December 15, 2022

Re: Jackson Ranch Filing No. 3 – Riprap Protection at Lots 4 and 5
MVE Project No. 61044

LOT 4 & 5
 DRAINAGE SWALE

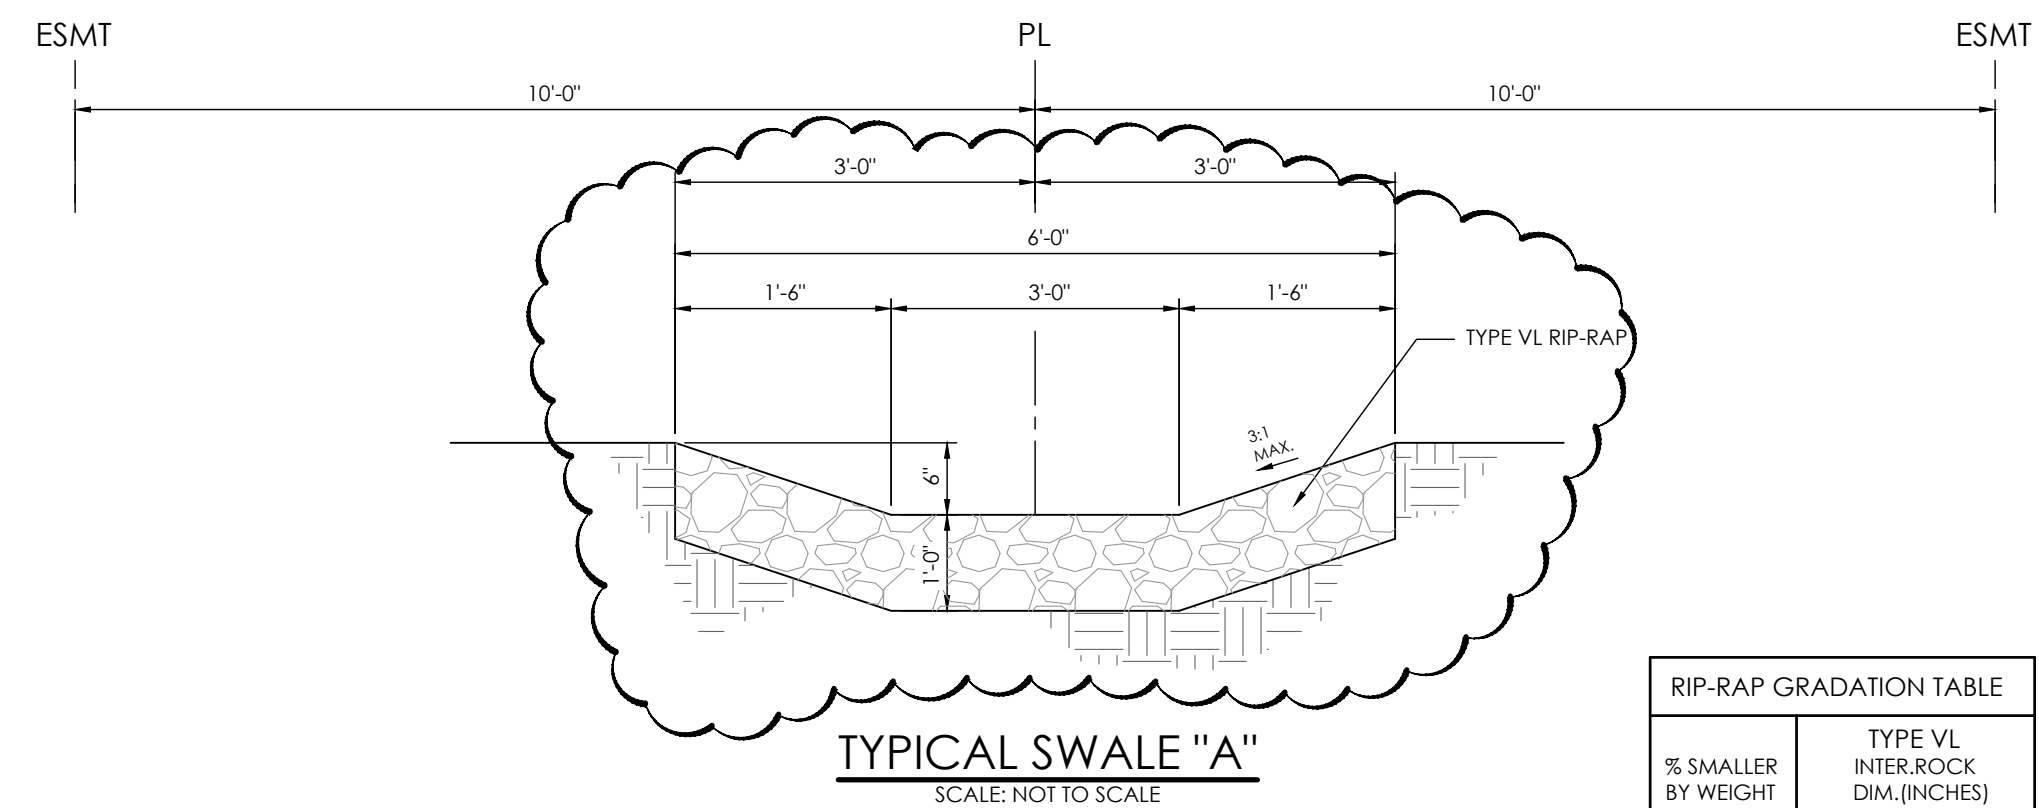
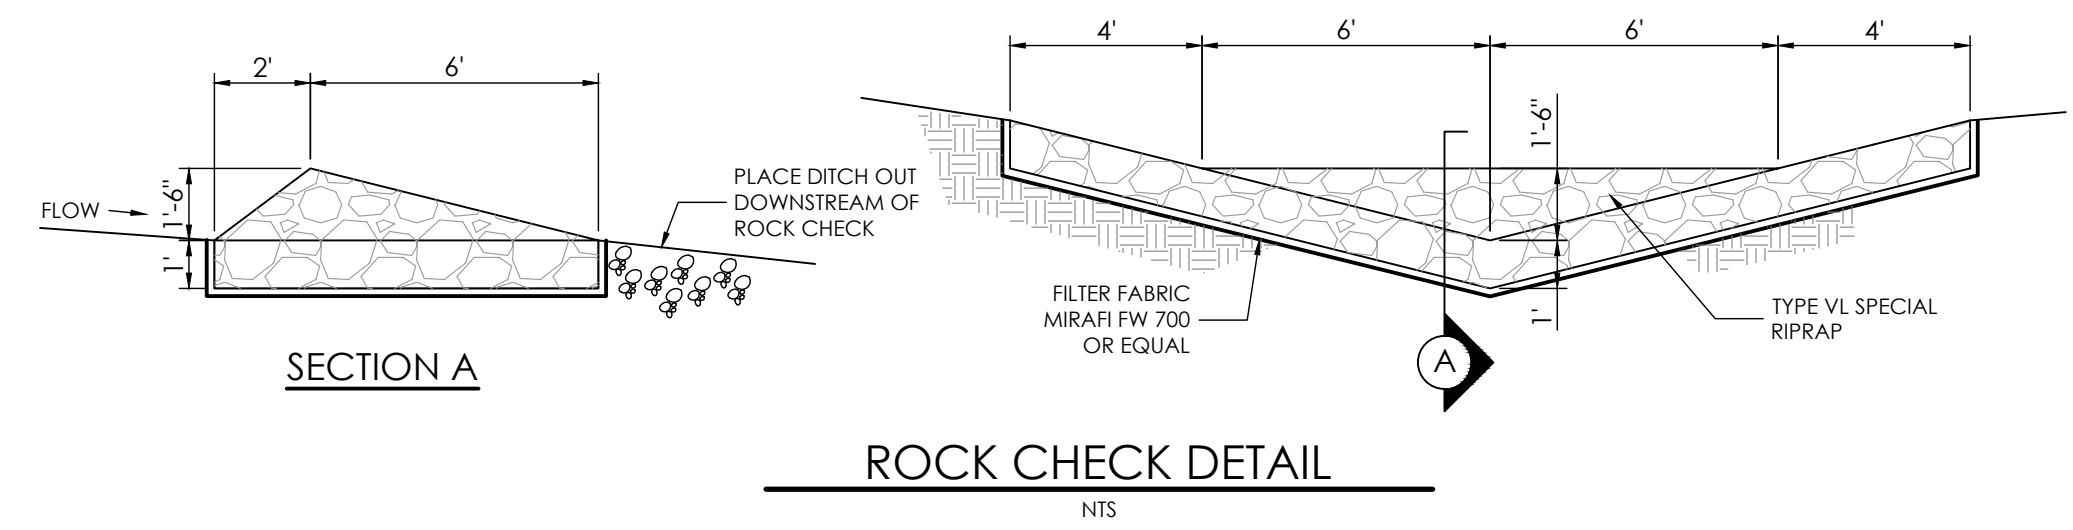
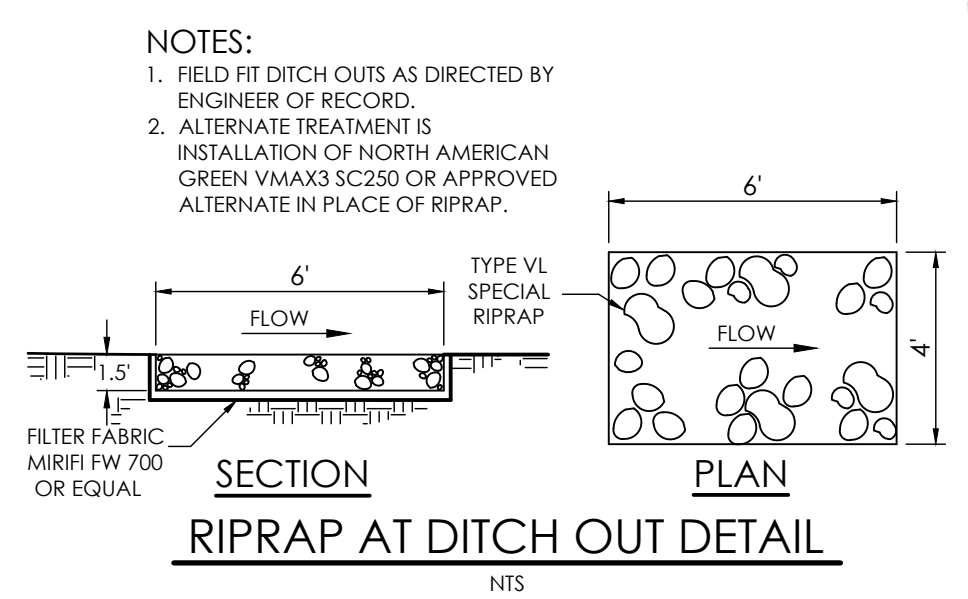
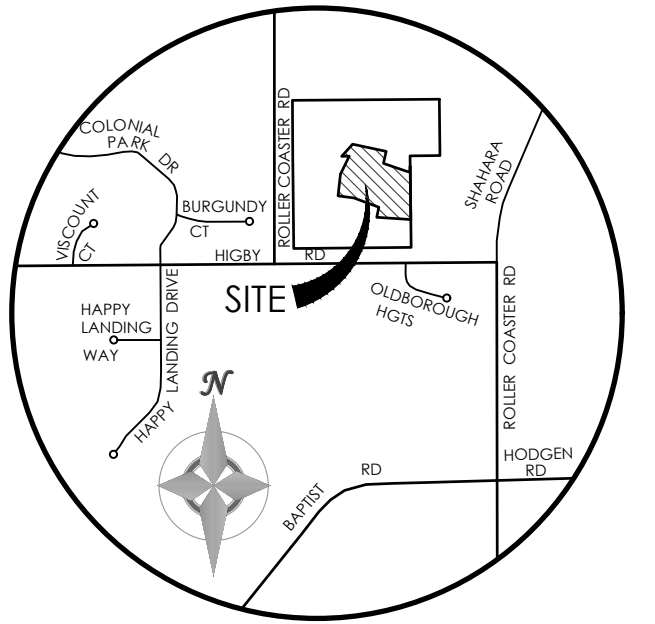
The construction drawings for Jackson Ranch Filing No. 3 included the addition of riprap protection for the drainage flow path located between lots 4 and 5. The alignment and extents of the riprap protect has been modified from the original plan design in the field by request of the lot purchasers. Based on field observation, M.V.E., Inc. is of the opinion that the riprap protection for the referenced private property has been constructed in an adequate manner and the flow path is stabilized as required by the El Paso County Engineering Criteria Manual.
